Gate Burton Issue Specific Hearing (ISH) 2 - Draft DCO

7000 Acres is an interested party in the DCO Examination for the Gate Burton Solar Project and three additional solar NSIPs in the local area.

PROJECT
Gate Burton Energy Park

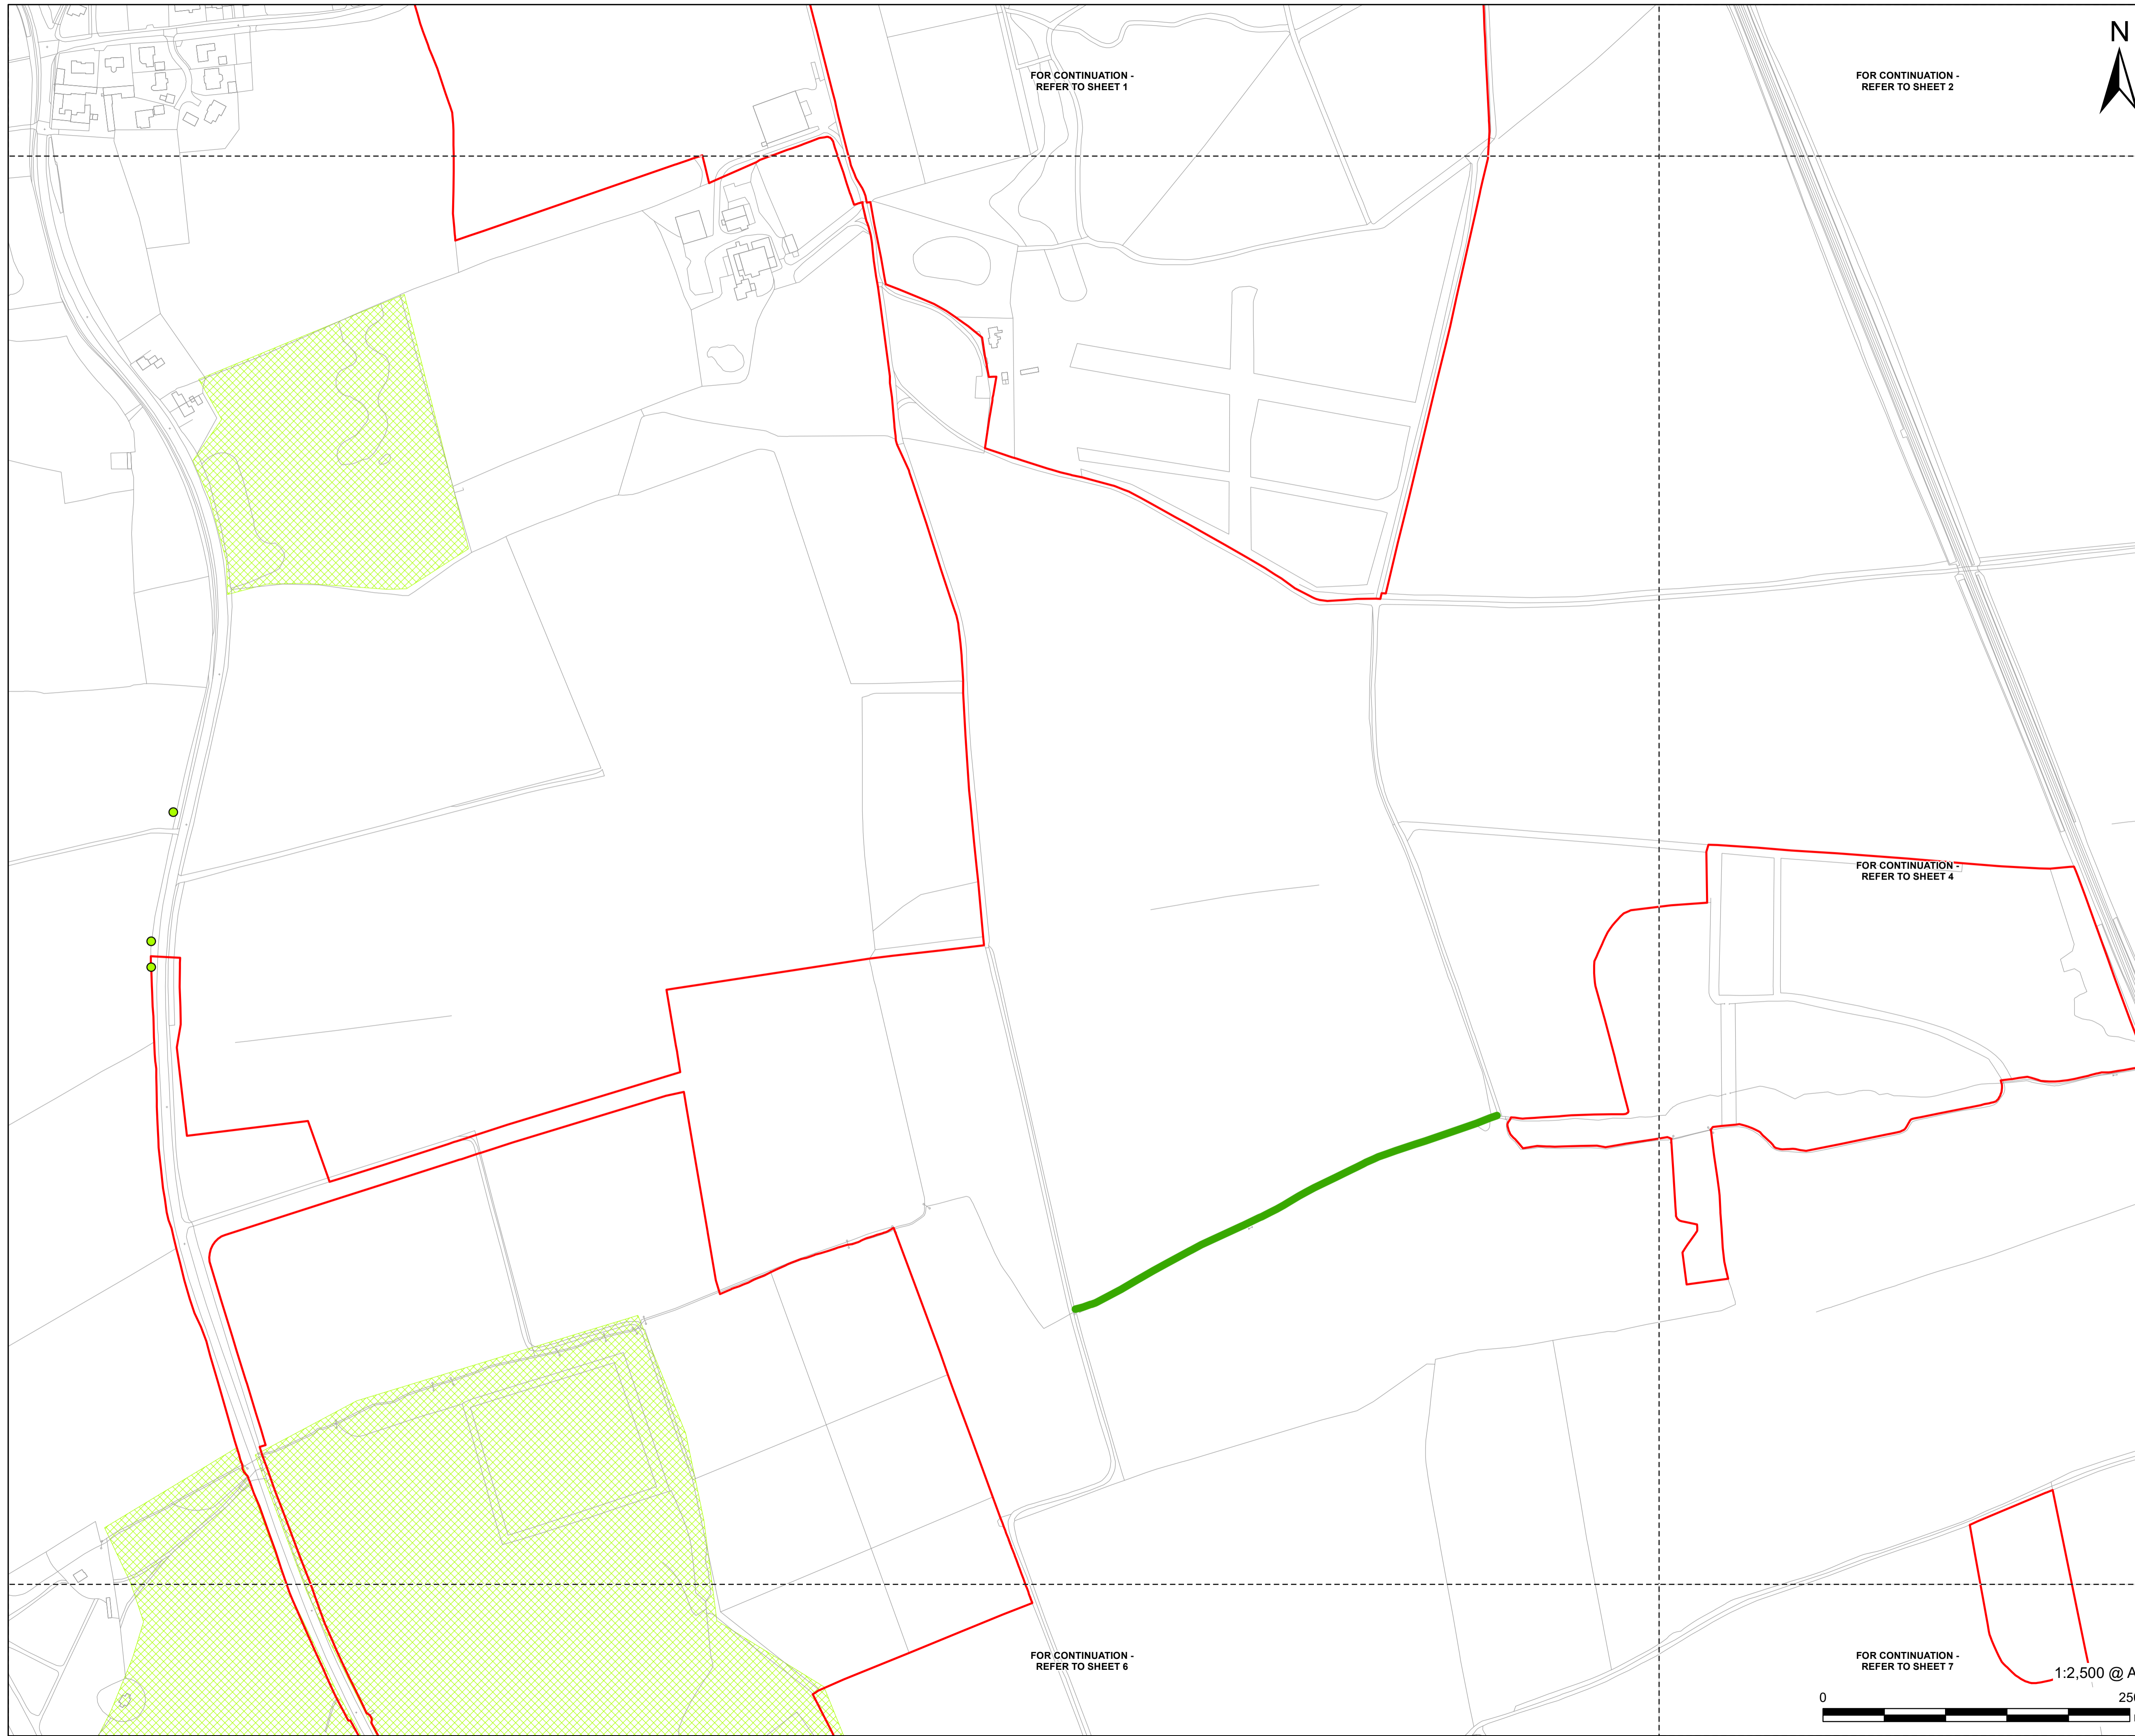
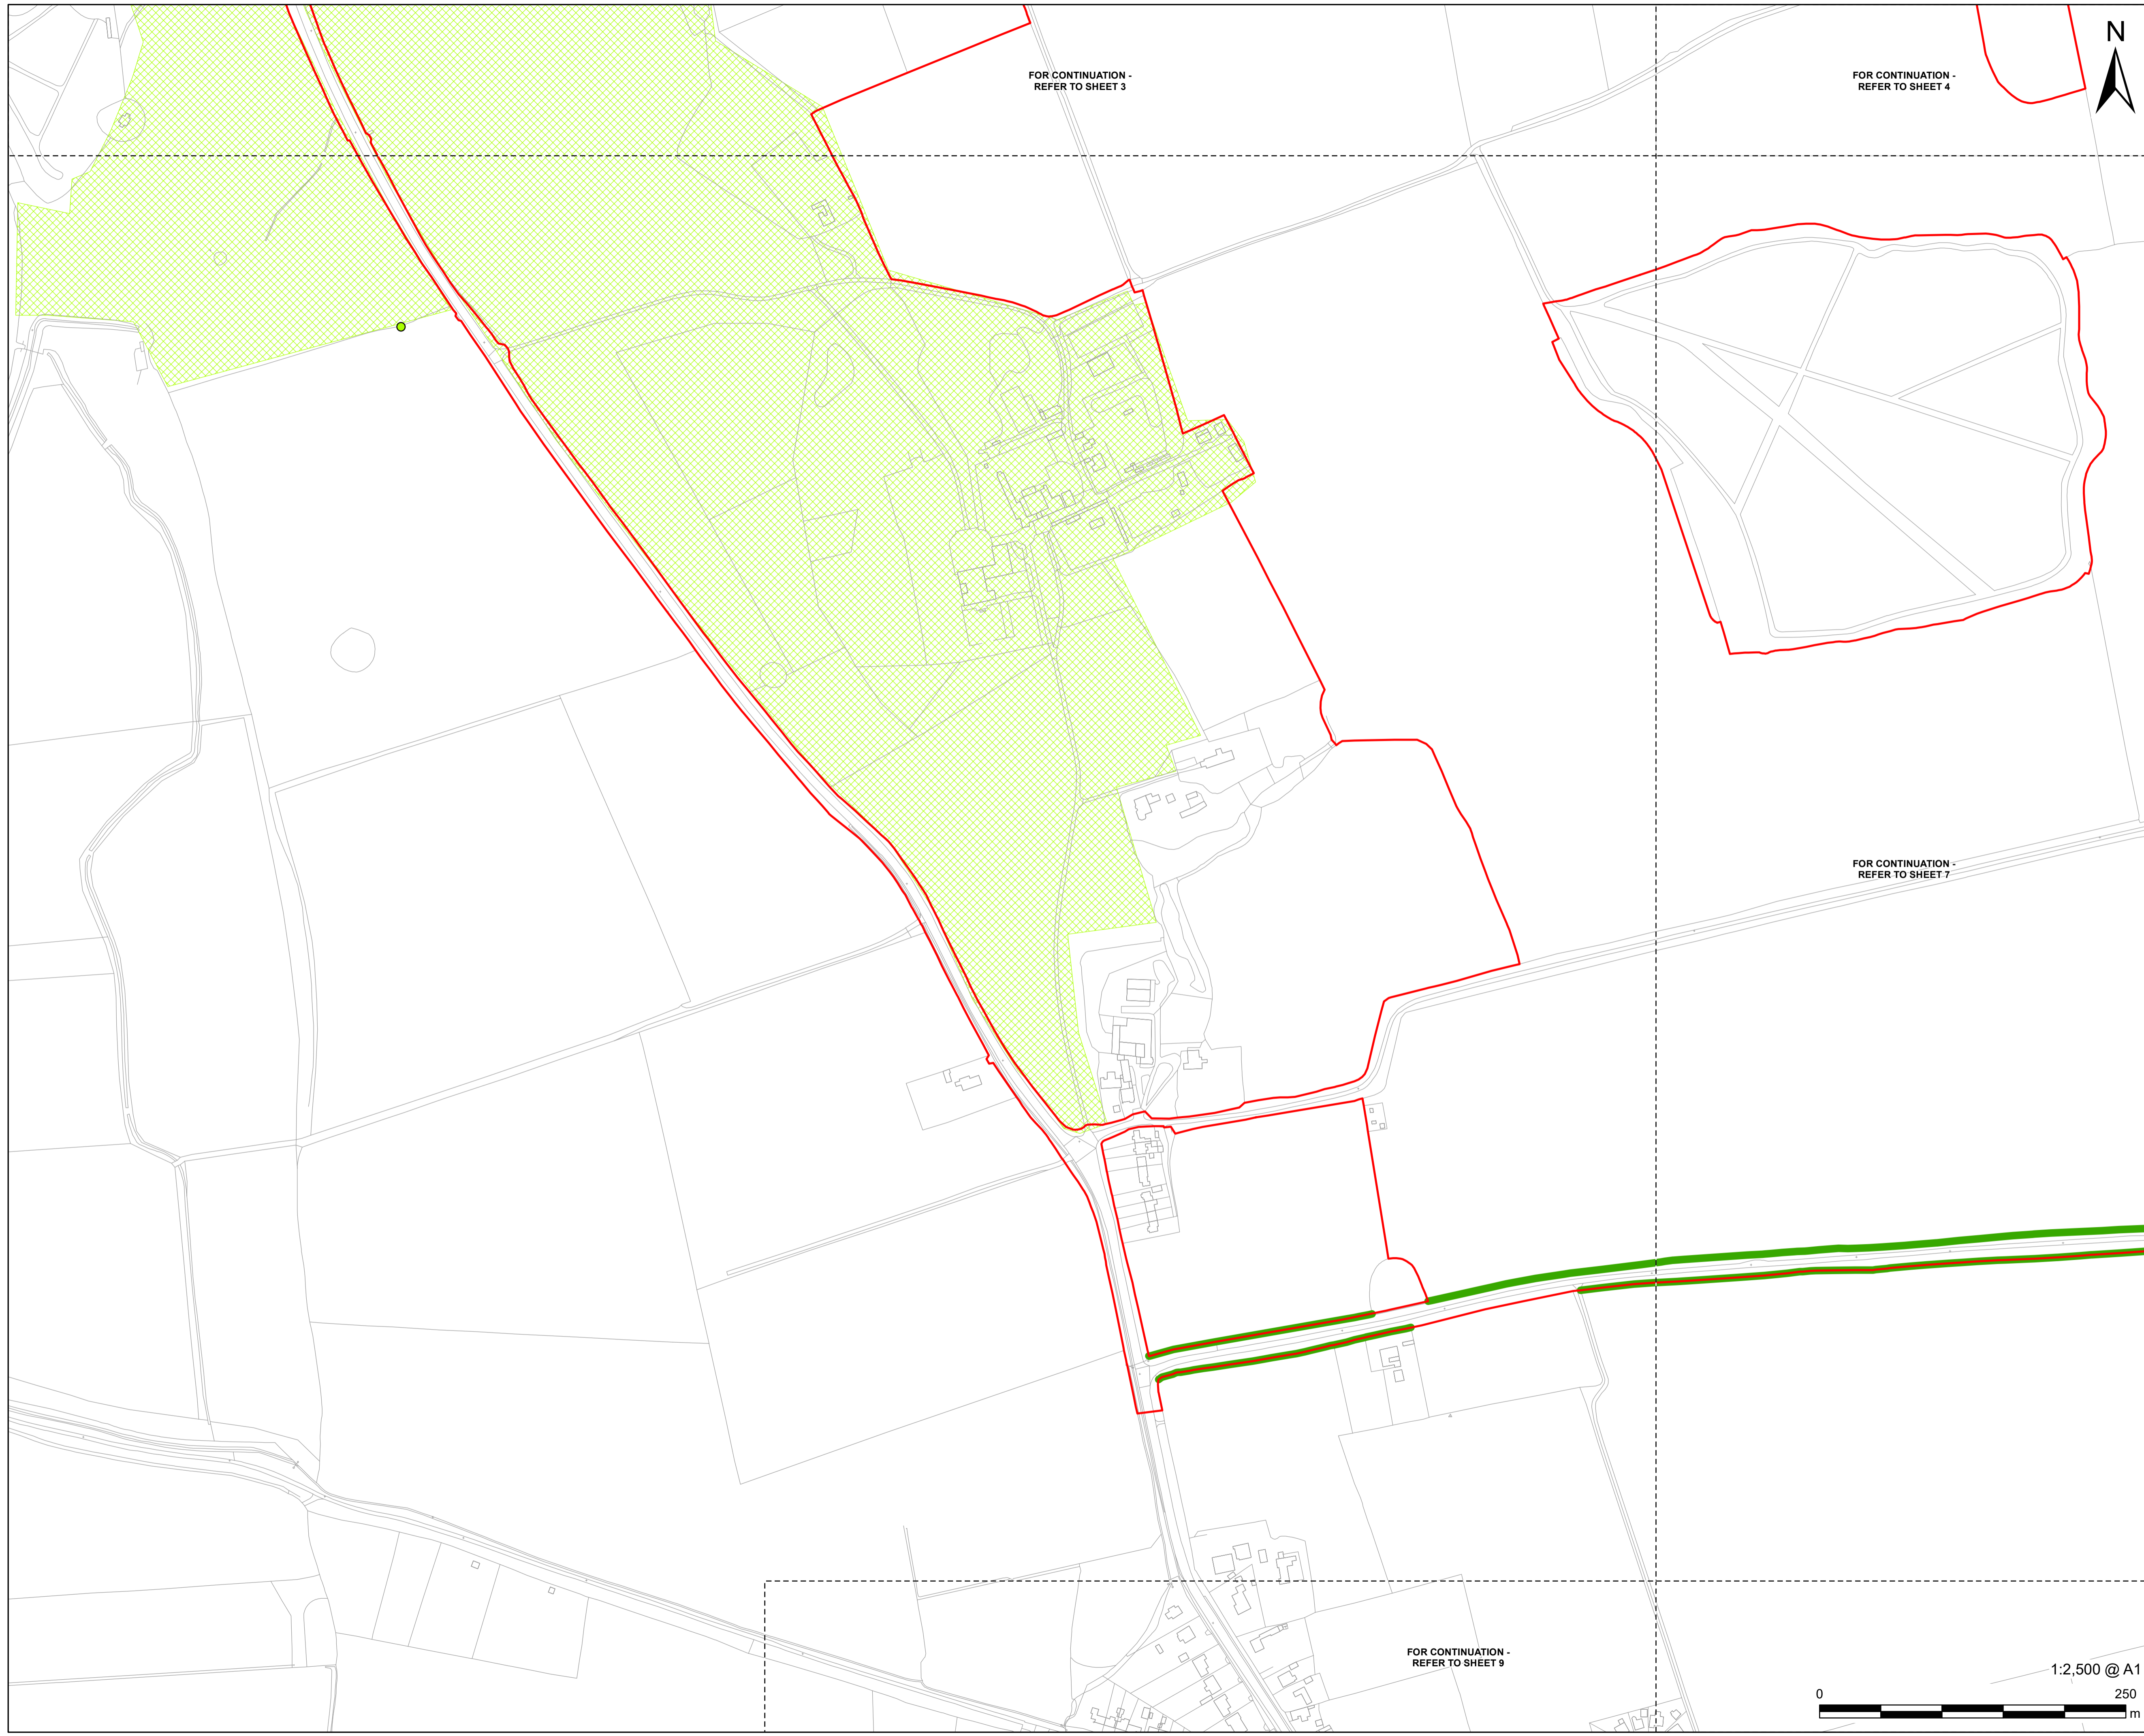
- The Applicant has failed to explain why in Requirements 38 and 39 they should have the ability to fell any tree or remove any hedge they wish. The current wording of the dDCO would allow the Applicant to remove all hedgerows and trees they believe to be necessary without any checks and balances. In the opinion of 7000 Acres, the dDCO should be revised to state that any lopping, pruning, felling or removal of hedgerows, trees or shrubs should be in accordance with the Landscape and Ecological Management Plan.
